## Nepean Hospital – Mental Health Unit

### Project Application – Response to Submissions

3 LEVEL 3
1 : 500

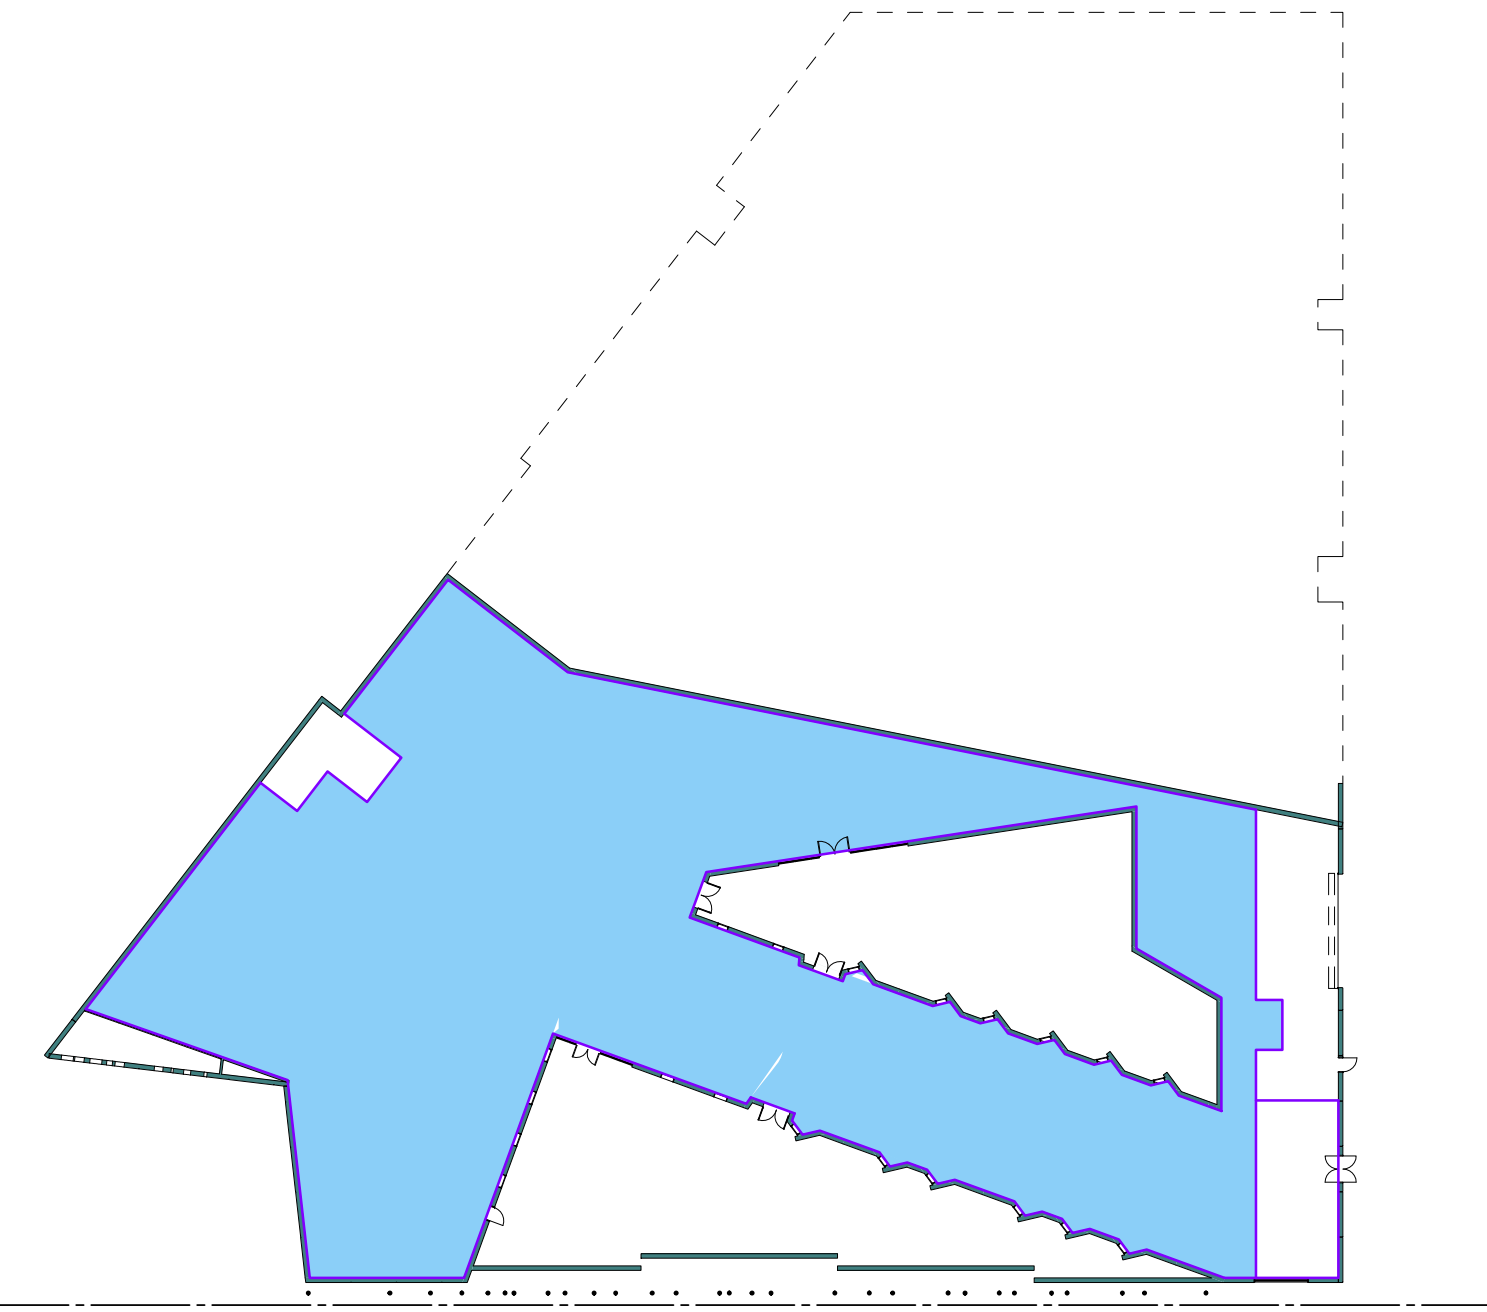
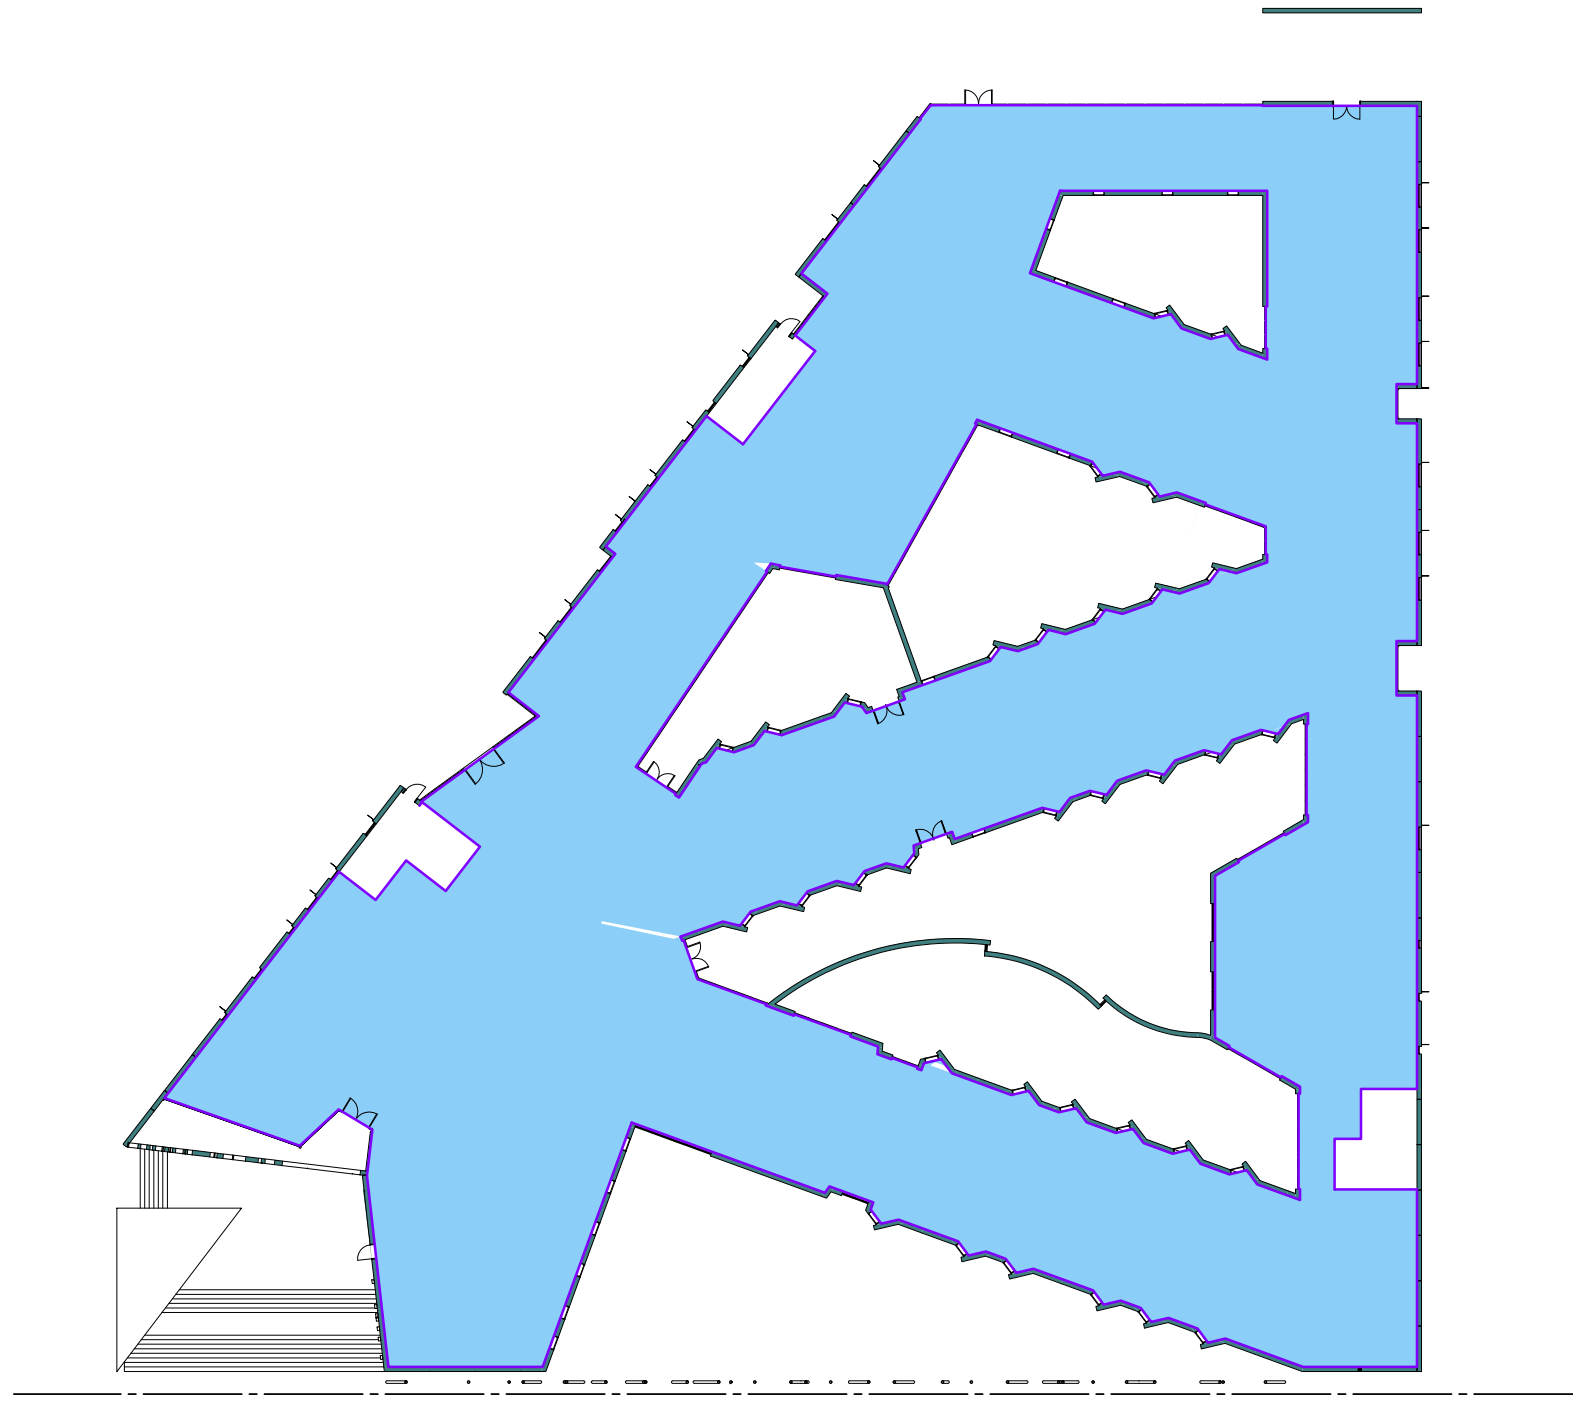
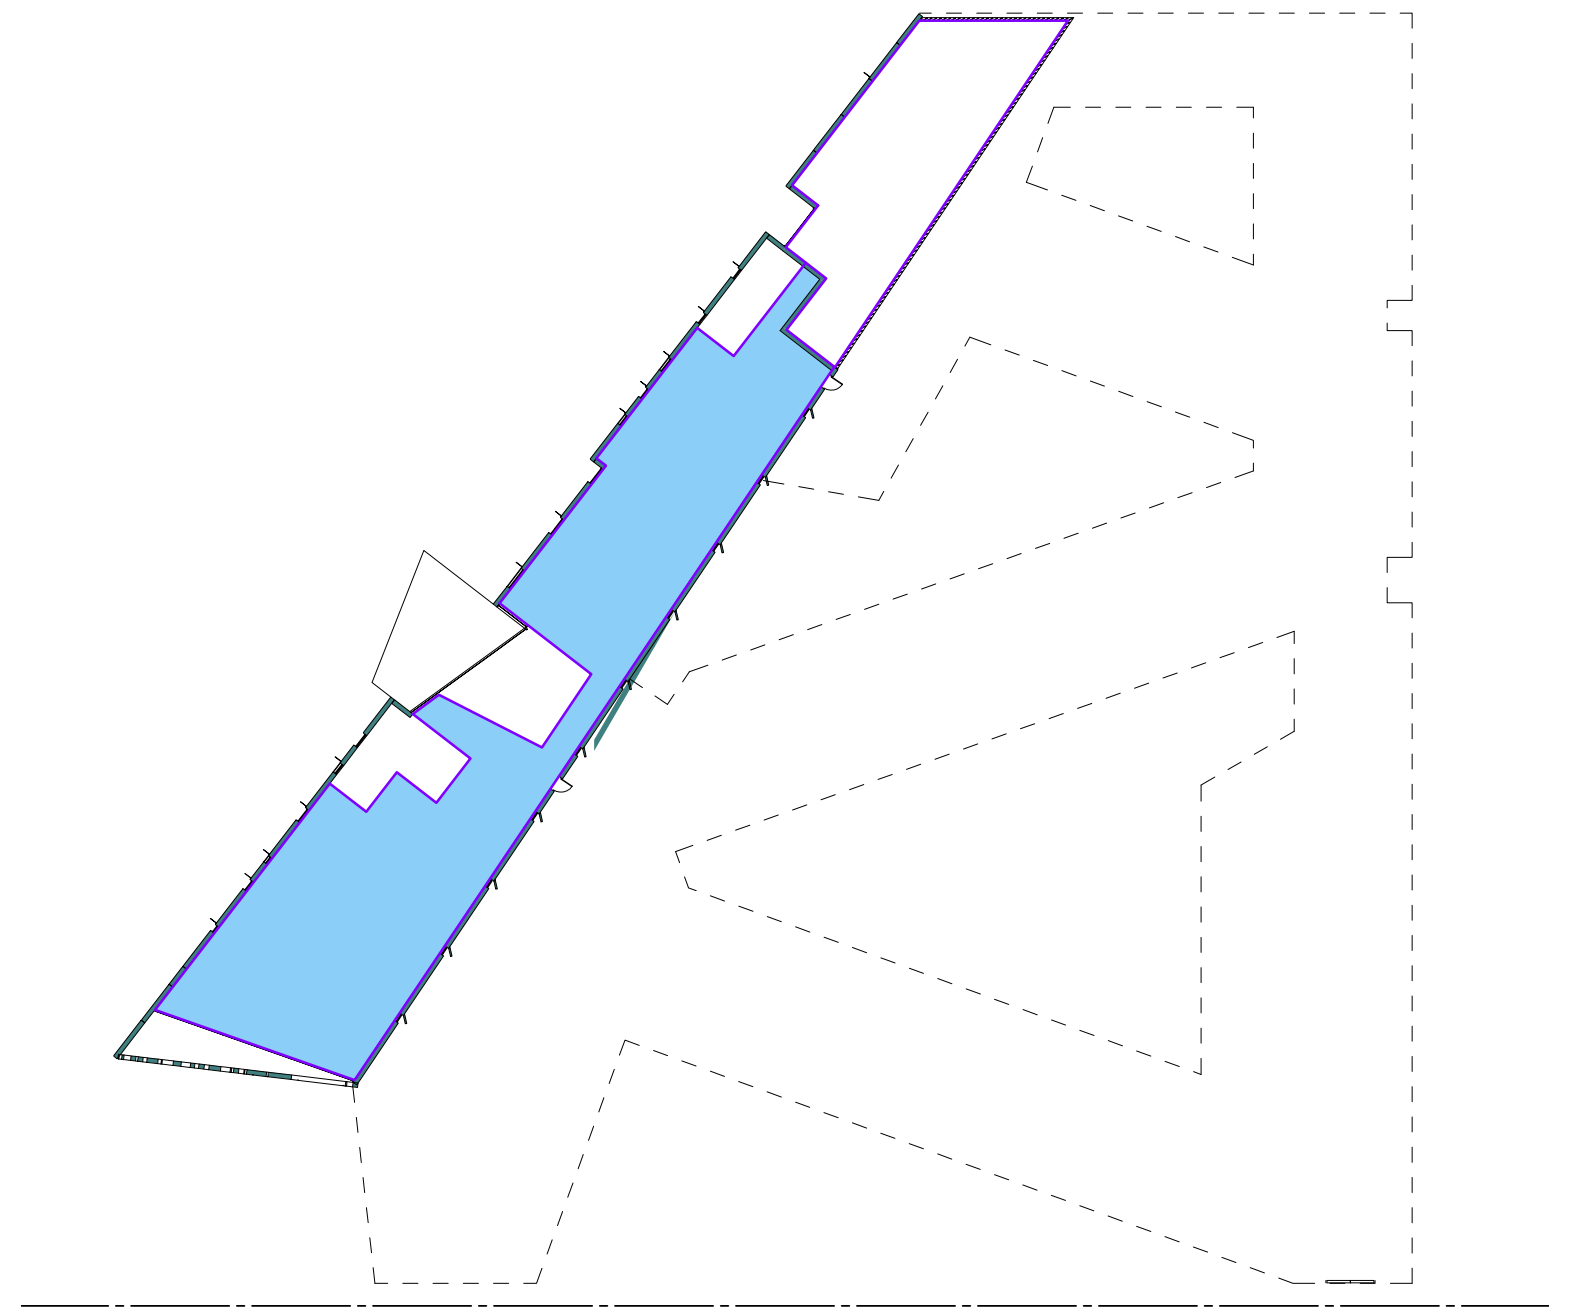
2	The proposed bicycle facilities include 10 staff lockers, 10 staff bicycle parking spaces and 5 visitor bicycle spaces. The application does not reflect any bicycle facility	Two showers are to be provided for cyclists with the staff amenities area on Level 3. Stanchions for locking bicycles and an awning over the bicycle

provision to reduce car parking impacts.	<p>parking area have been provided for security and weather protection.</p> <p>These cyclist facilities have been designed in accordance with the relevant provisions of the NSW Planning Guidelines for Walking and Cycling and will encourage staff and visitors to cycle to the IMHU.</p> <p>Further discussion relating to this issue is provided in <b>Section 2.2</b> of the PPR.</p>
3	The layout of the proposed car parking areas associated with the subject development (including driveways, grades, turning paths, sight distances, aisle widths, aisle lengths and parking bay dimensions) should be in accordance with AS2890.1-2004 and AS2890.2-2002.	Noted
4	The swept path of the longest vehicle (to service the site) entering and exiting the subject site, as well as manoeuvrability throughout the site, shall be in accordance with AUSTROADS. In this regard, a plan shall be submitted to the Department for approval which shows that the proposed development complies with this requirement. The Department should ensure that service areas are separated from general parking areas to reduce vehicle conflict points.	Noted
